Immingham Green Energy Terminal

10.8 Proposed Further Change Application Report

June 2024

Document Reference: TR030008/EXAM/10.8

LEGEND

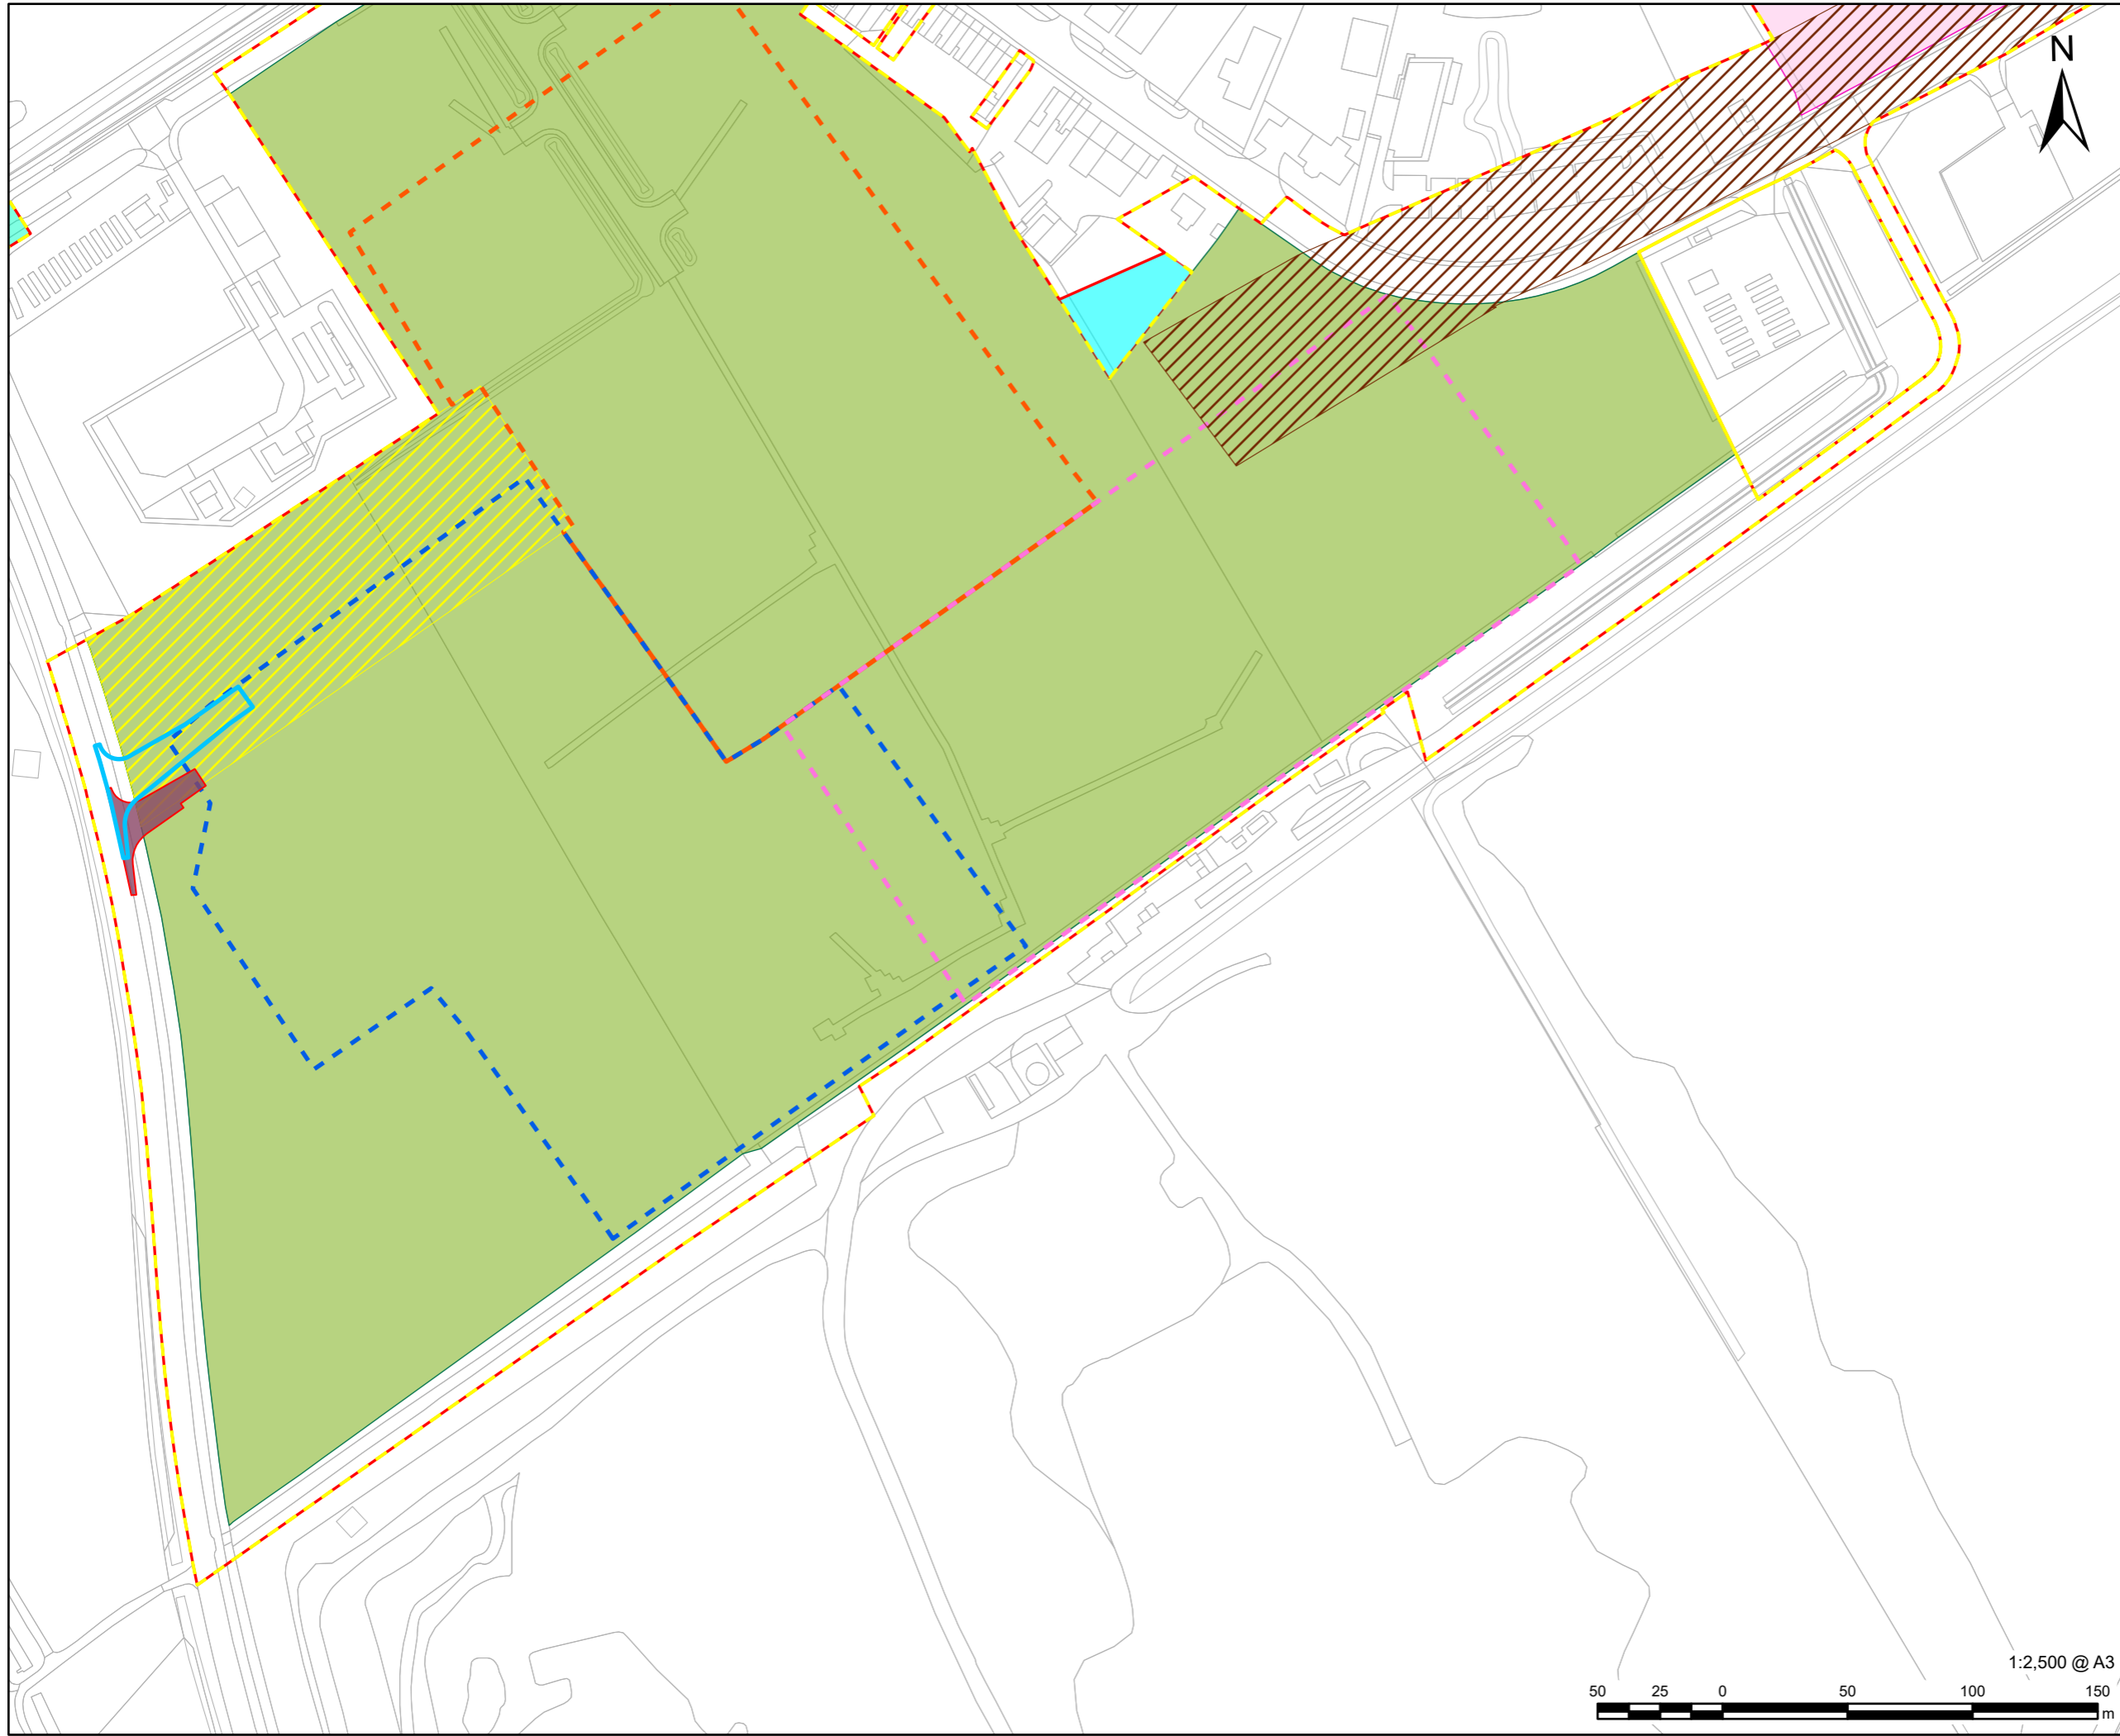
2.6.1 Proposed Change 7 consists of a beneficial reduction in the area of Work No. 9 (2.64 ha). Work No. 9 is proposed to be used for temporary construction purposes and temporary possession powers are sought in relation to Work No. 9 during the construction period.

2.6.2 The reduction in Work No. 9 is proposed following engagement with two parties. First, the Environment Agency has indicated that there is a small area of Work No. 9 close to the North Beck Drain which is liable to flood and so should not be used for construction purposes. Additionally, during engagement with the owner of part of Work No. 9 on the terms of an agreement for lease of that land, the owner expressed a desire to retain possession of a particular part of the land for its own purposes. After further review of the land required for construction purposes based on latest information, the Applicant has concluded that these requests can be accommodated and have the benefit of enabling the reduction of the area required for Work No. 9, and also the Order limits, as well as reducing the area subject to powers of temporary possession in connection with the Project.

2.6.3 **Appendix 1** illustrates the location of the proposed change and **Appendix 2** illustrates the reduction in the Order limits as a result of the reduction in the area of Work No. 9.

Drawing Number	Project	Originator	Volume	Rev
60673509	-ACM	-XXX	-	P02
Location	Type	Role	Number	
ZZ	-DR	-CH	0002

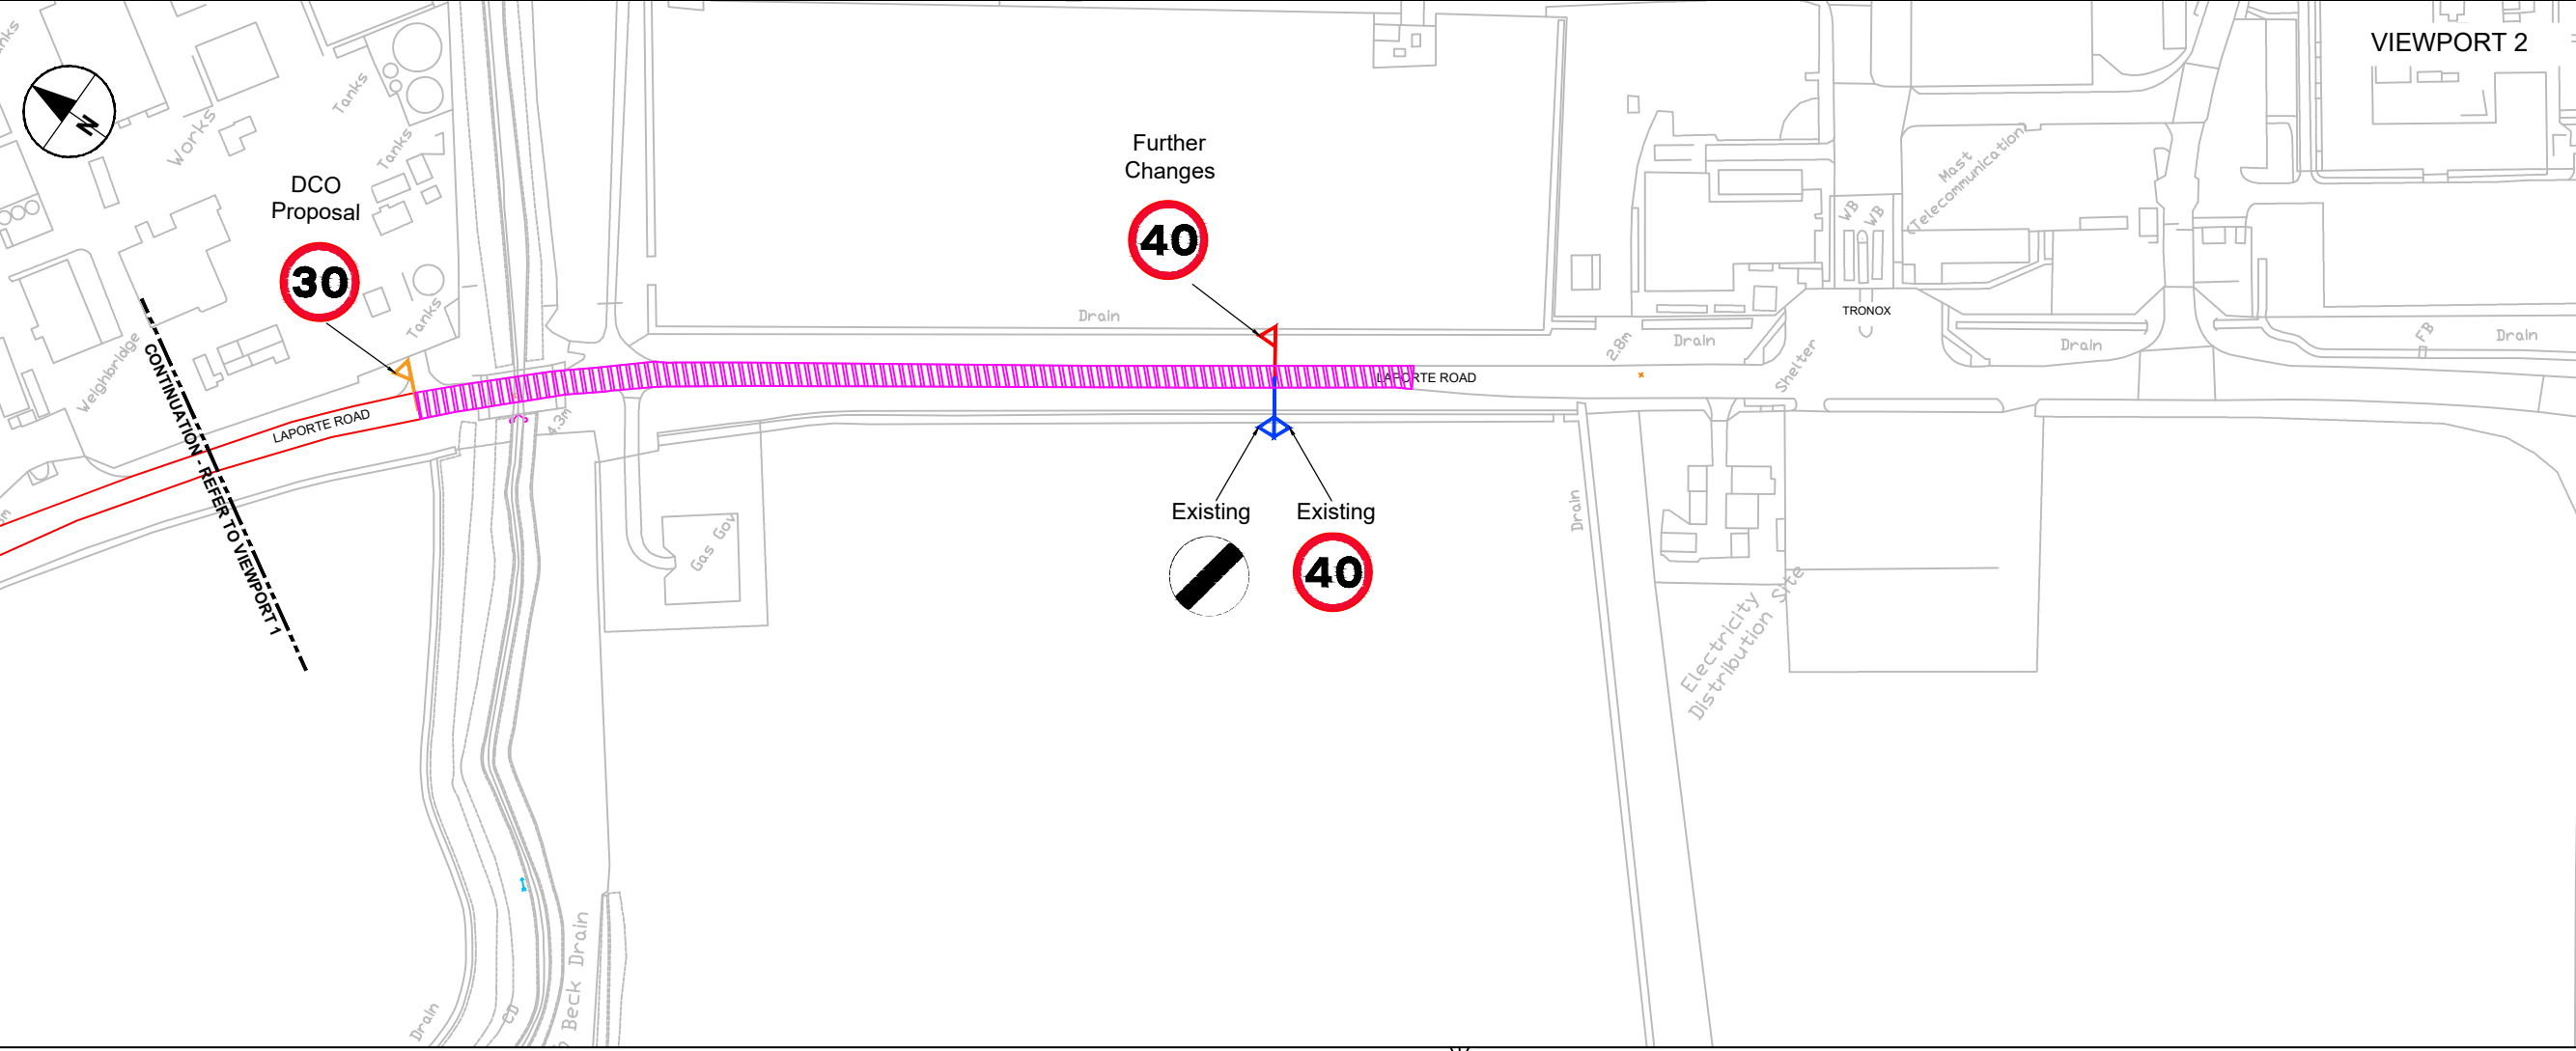
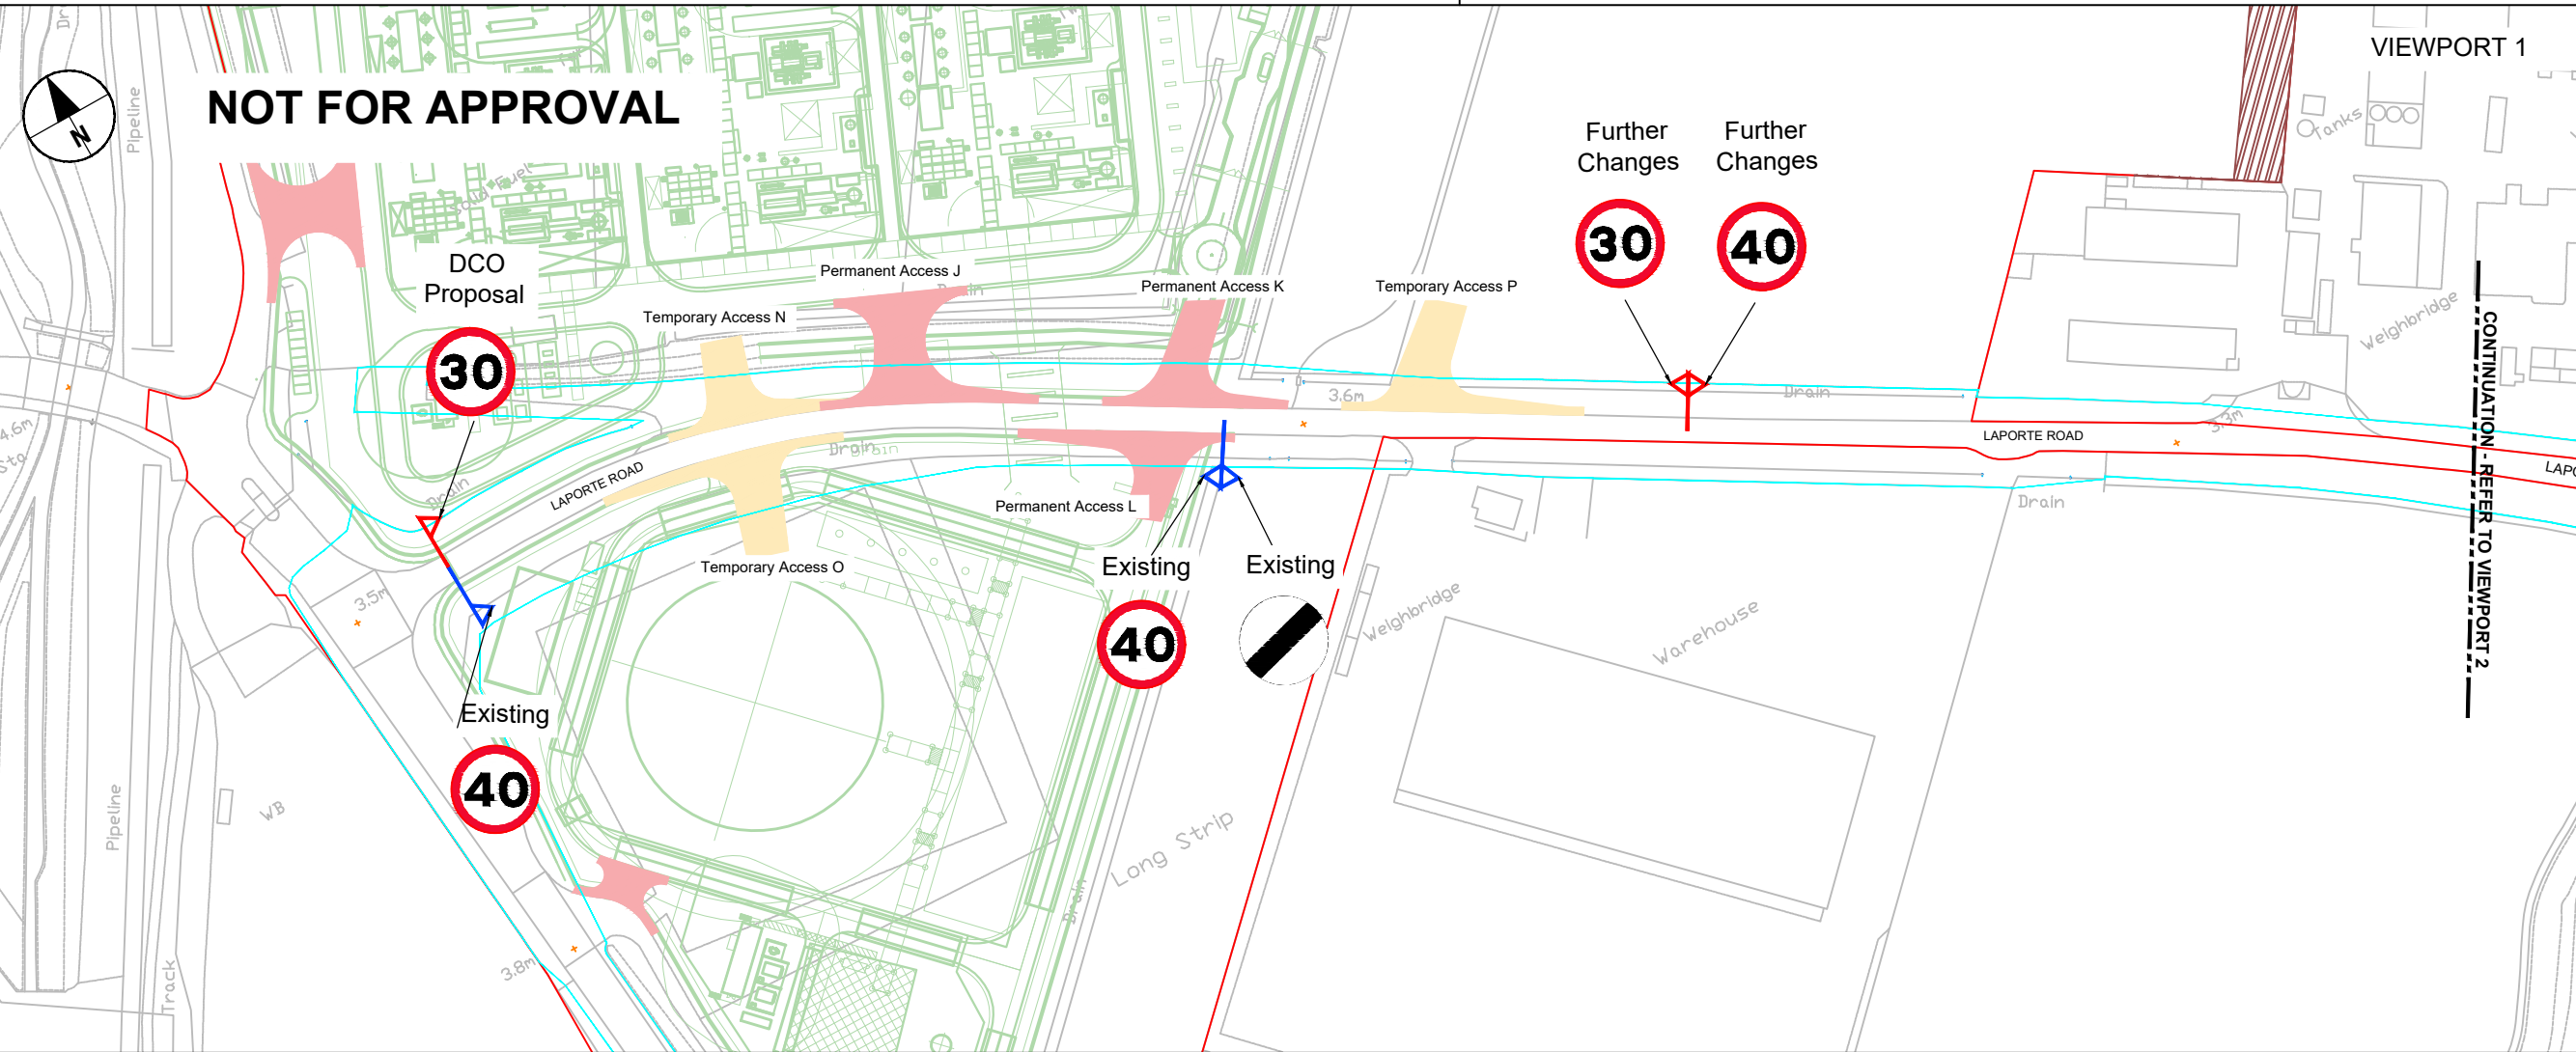
- 2.4 Proposed Change 5(c): Adjustments to speed limit change on Laporte Road & extension of Order limits
 - 2.4.1 Adjustments are proposed to the way that the speed limit change agreed with NELC is to take effect along Laporte Road. As shown on the **Traffic Regulations Measures Plan [TR030008/APP/4.8(4)]**, the Application currently proposes that

the speed limit for a length of Laporte Road is reduced permanently to 30mph past the entrances to Work No. 3 and Work No. 5.

- 2.4.2 NELC Highways has requested that the limits be consolidated in order to better reflect existing controls and to remove what would be a short section of 60mph limit, thereby smoothing the speed limit changes.

- 2.4.3 It is therefore proposed that the 30mph limit will apply to Laporte Road from the junction with Queens Road (marked D on the **Traffic Regulations Measures Plan [TR030008/APP/4.8(4)]**) for approximately 365m to the point marked BC on the **Traffic Regulations Measures Plan**. A limit of 40mph is proposed from point marked BC for approximately 545m to the point marked E on the **Traffic Regulations Measures Plan** which is where the existing limit on Laporte Road reduces to 40mph. This requires a short extension (approximately 305m) of the Order limits along the public highway of Laporte Road to encompass the new 40mph section. **Appendix 1** illustrates the location of the proposed change. **Appendix 2** illustrates the proposed adjustments and the proposed extension to the Order limits to reflect Proposed Change 5(c) and **Appendix 4** illustrates the locations of the proposed changes to speed limits. The eastern extent of the proposed new section with a 40mph speed limit is aligned to the point on Laporte Road where the existing 40mph section commences. The **Street Works and Accesses Plan [TR030008/APP/4.6(3)]** and **Traffic Regulations Plan** show the final proposed extent of the speed limit change.
